City of Albuquerque SWPPP Inspection Checklist

| Project Name: | SAGE RANCH | Project Operator: | |
| Date of Inspection: | 12/28/23 | Contact Email: | |

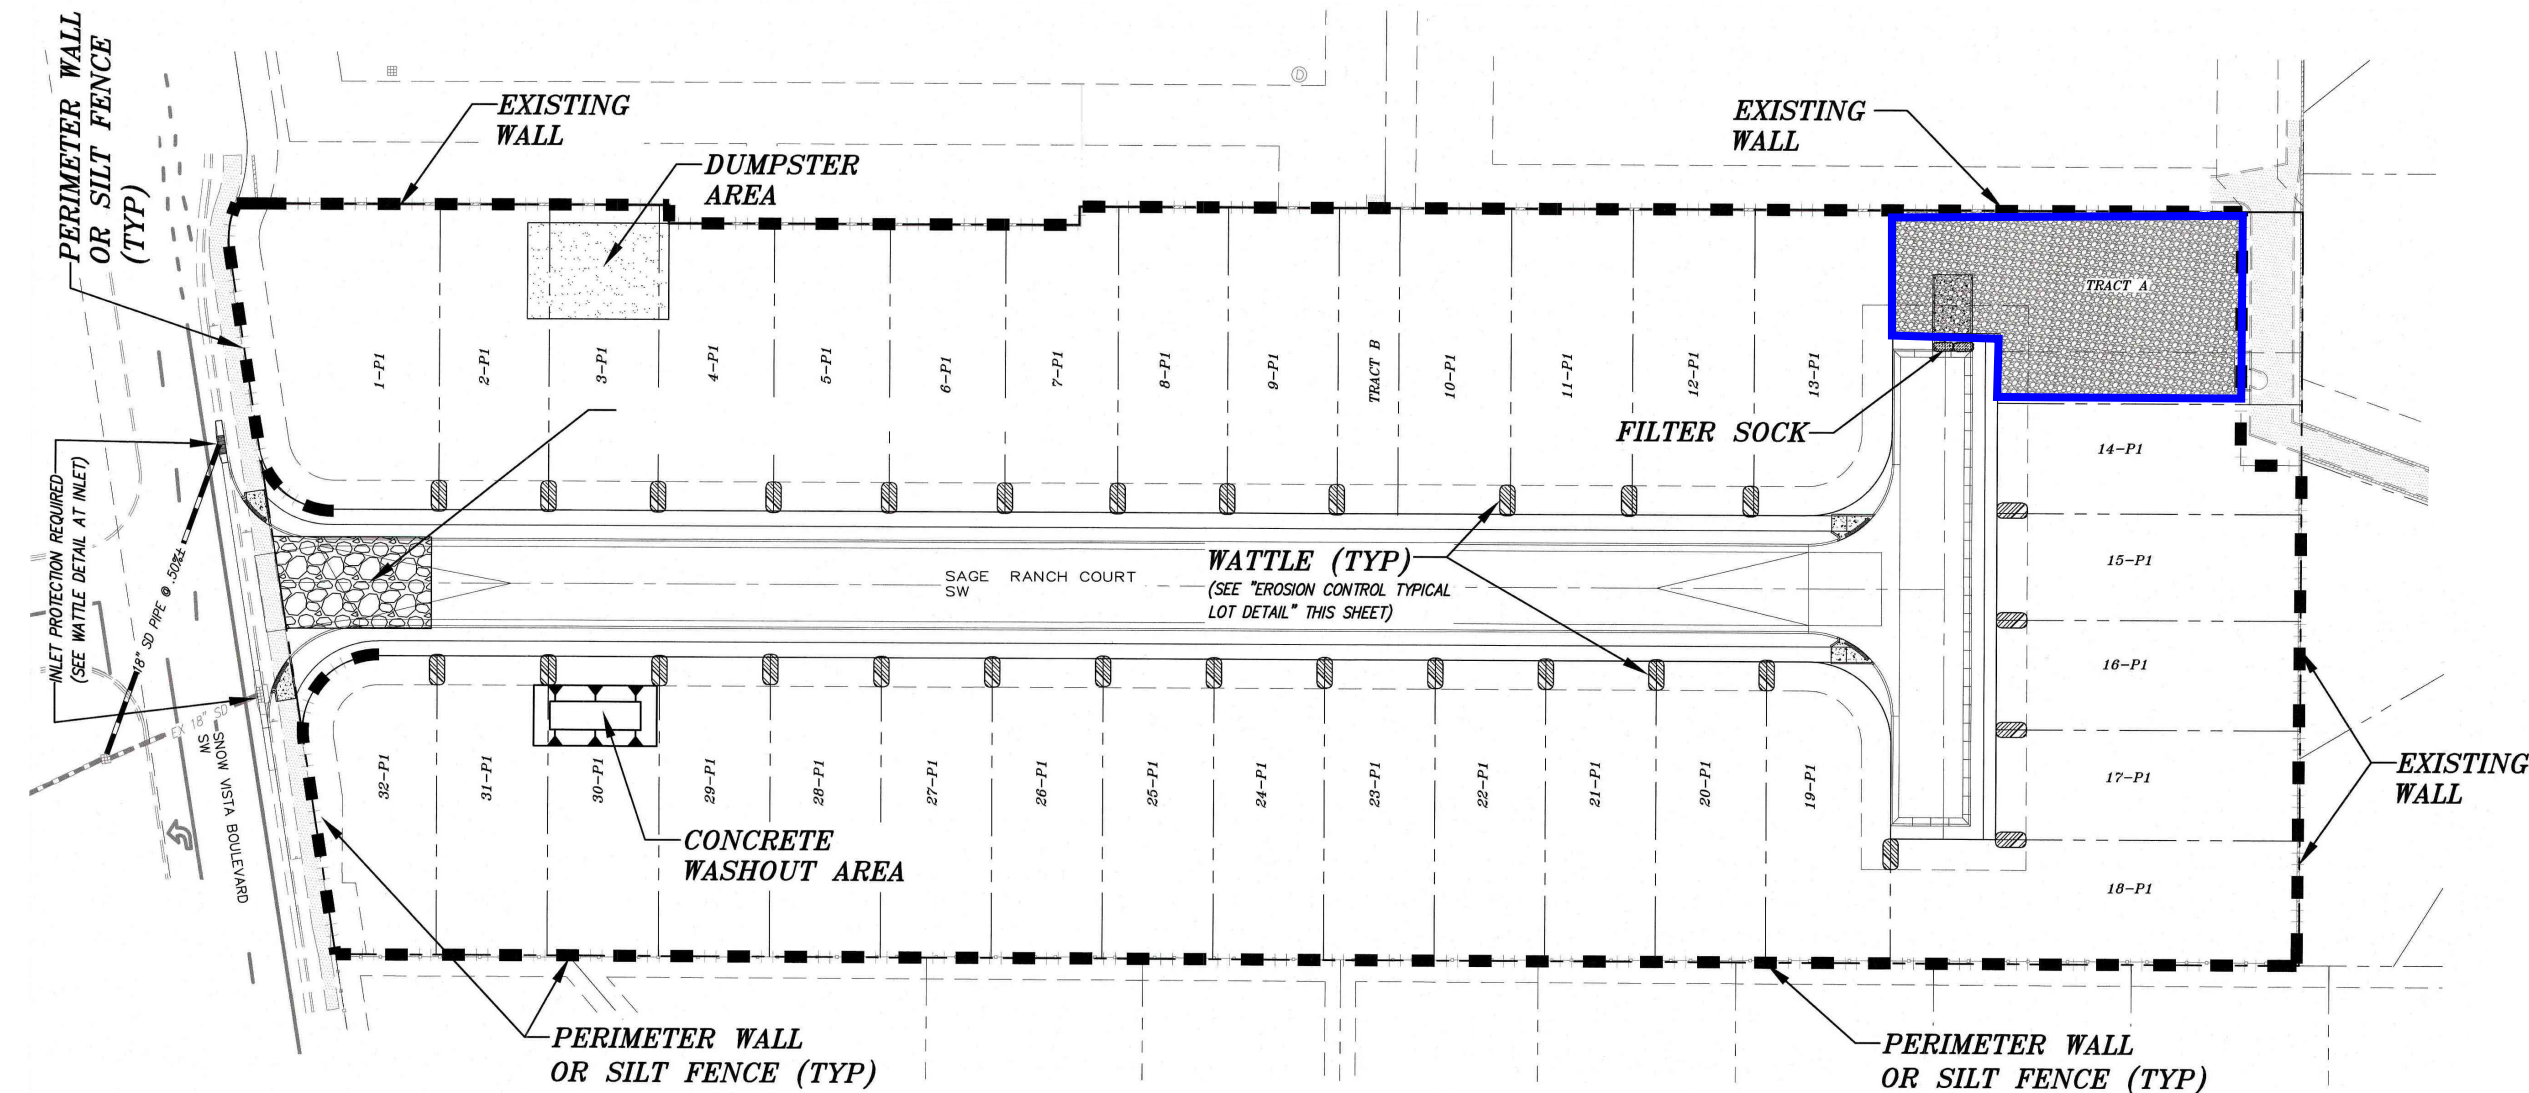
| SWPPP Requirements | CGP (SWPPP – EPA Template) | YES | NO | COMMENTS |
|--|---|-------------------------------------|-------------------------------------|-----------------|
| Has the site map been updated? | 7.2.4, 7.4 (App A) | <input type="checkbox"/> | <input type="checkbox"/> | N/A |
